Our Ref: ID 3928
Your Ref: SSD-89050708

8 July 2026

State Significant Development Application for Mixed Use Development, Corner of Union and Kenrick Streets, The Junction (EIS)

REVISION	R.10 SSDA 04.05.2026
DRAWING	FLOOR PLAN GROUND
NUMBER	A-14

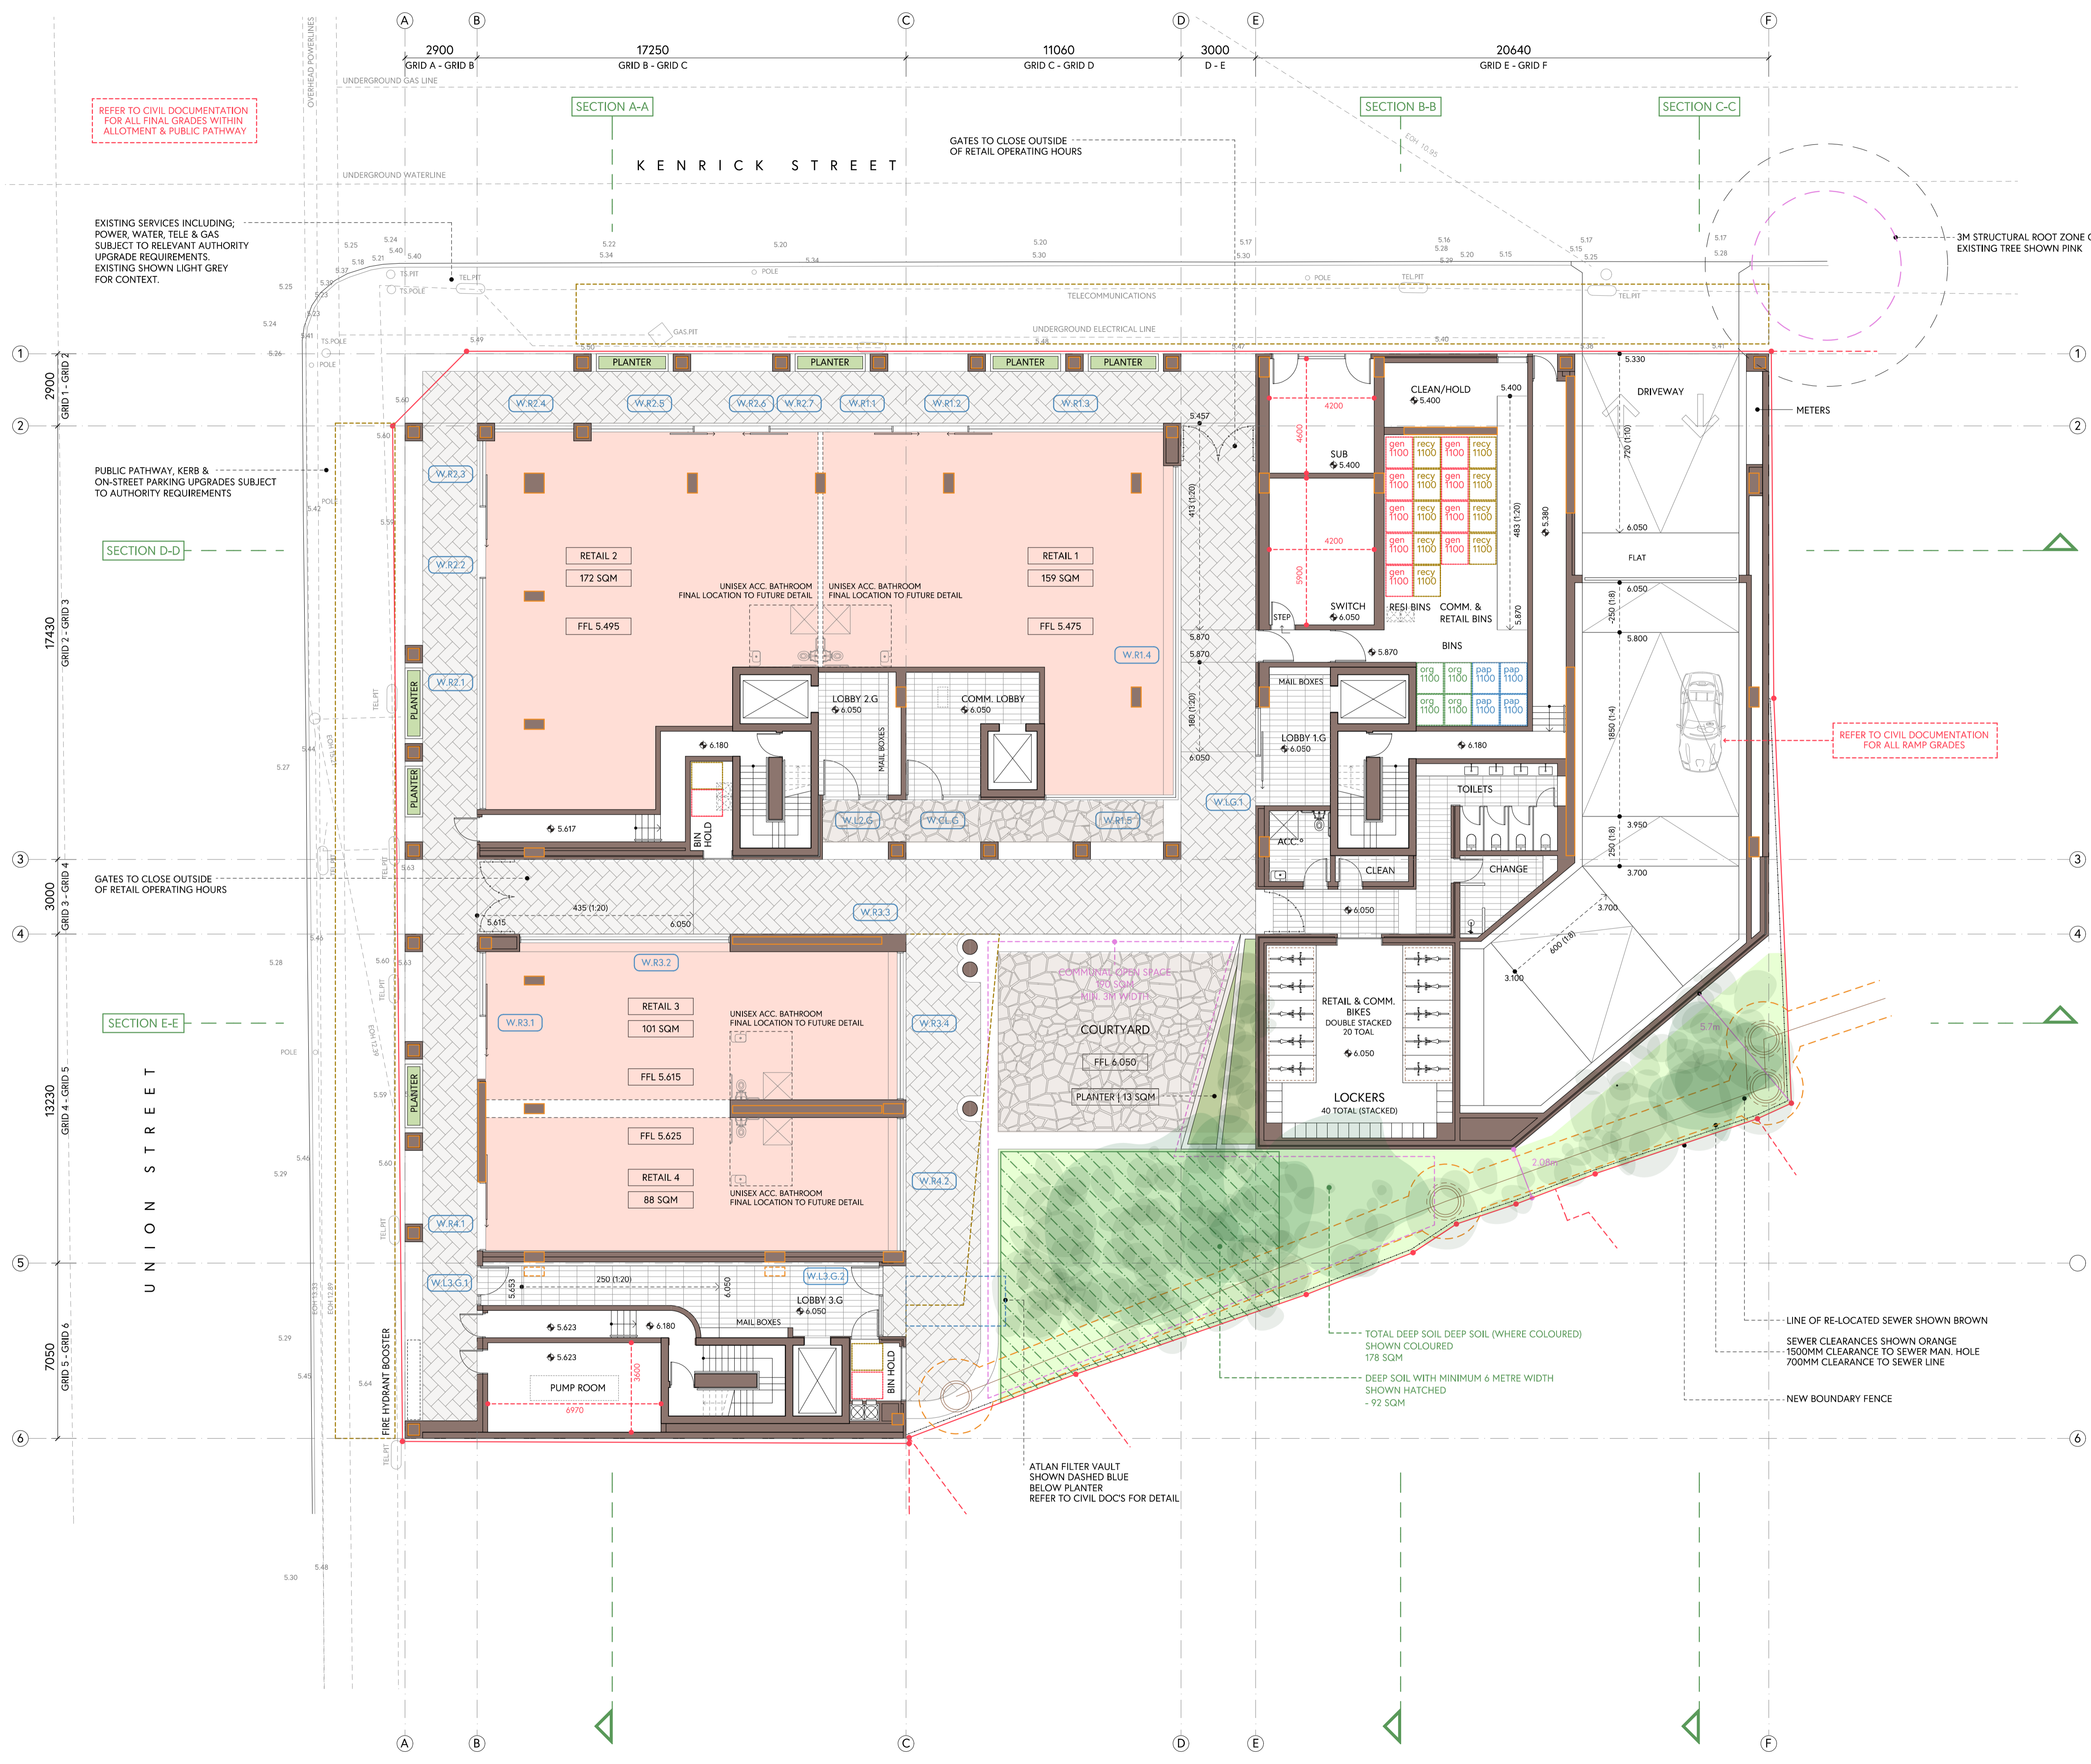
- design criteria considerations such as providing appropriate space (minimum 2 m² per person), protection from weather and appropriate heating and cooling, which the proposal does not currently provide due to most of the proposed shelter space being outdoors (courtyard, access ramps), along with an entry hallway (next to the bicycle lockers) and the three lobbies.⁷

- **Note** and appreciate the development proposes all commercial spaces and residential dwelling on Level 1 (at 10.7 m AHD) and above, which are well above the PMF level. It also proposes passive protection measures for the basement parking, with a driveway crest level at 6.05m AHD,⁸ and providing ramped access to the building lobbies and the communal open space (courtyard), with floor levels for these Ground Floor components set at 6.05m AHD.⁹ However, the floor levels of all retail spaces (between 5.47m AHD – 5.62m AHD), the pump room (5.62m AHD), the substation (5.4 m AHD) and the commercial & retail waste storage area (5.87m AHD) are below the FPL (6.0m AHD) and the PMF level (6.0m AHD).¹⁰ This suggests that most of these areas are not protected to the FPL, as suggested in the EIS,¹¹ **and would be subject to over floor flooding in the 1% AEP event** (except for the waste storage area) and more severe events. We therefore **recommend** carefully considering building design and layout to minimise risk to life, property and disruption to essential services, by providing improved flood immunity for the retail spaces and relocating any critical infrastructure (*such as the substation*) away from the flood affected area of the building to an area above the PMF, where feasible. Consideration could also be given to installing washable finishes and/or removable infrastructure which would otherwise be subject to floodwater damage and contamination.

We note the development proposes all commercial spaces and residential dwelling on Level 1 (at 10.7 m AHD) and above, which are well above the PMF level, while also providing passive protection for the basement parking - with a driveway crest level at 6.05m AHD,¹⁹ and providing ramps up to the lobbies and the communal open space (courtyard) area - with floor levels for these parts of the Ground Floor set at 6.05m AHD.²⁰ However, we note that the floor levels of all retail spaces (between 5.47m AHD – 5.62m AHD), the pump room (5.62m AHD), the substation (5.4 m AHD) and the commercial & retail waste storage area (5.87m AHD) are below the FPL and the PMF level of 6.0m AHD.²¹ This suggests that most of these areas **are not protected to the FPL**, as suggested in the EIS,²² **and would be subject to over floor flooding in the 1% AEP event** (except for the waste storage area) and more severe events.

We **recommend** carefully considering building design and layout to minimise risk to life, property and disruption to essential services, by providing improved flood immunity for the retail spaces and relocating any critical infrastructure (*such as the substation*) away from the flood affected area of the building to an area above the PMF, where feasible. Consideration could also be given to installing washable finishes and/or removable infrastructure which would otherwise be subject to floodwater damage or contamination.

- design criteria considerations such as providing appropriate space (minimum 2 m² per person), protection from weather and appropriate heating and cooling – which the proposal does not currently provide due to most of the proposed shelter space being outdoors (courtyard, access ramps) along with an entry hallway (next to the bicycle lockers) and the three lobbies.²⁸
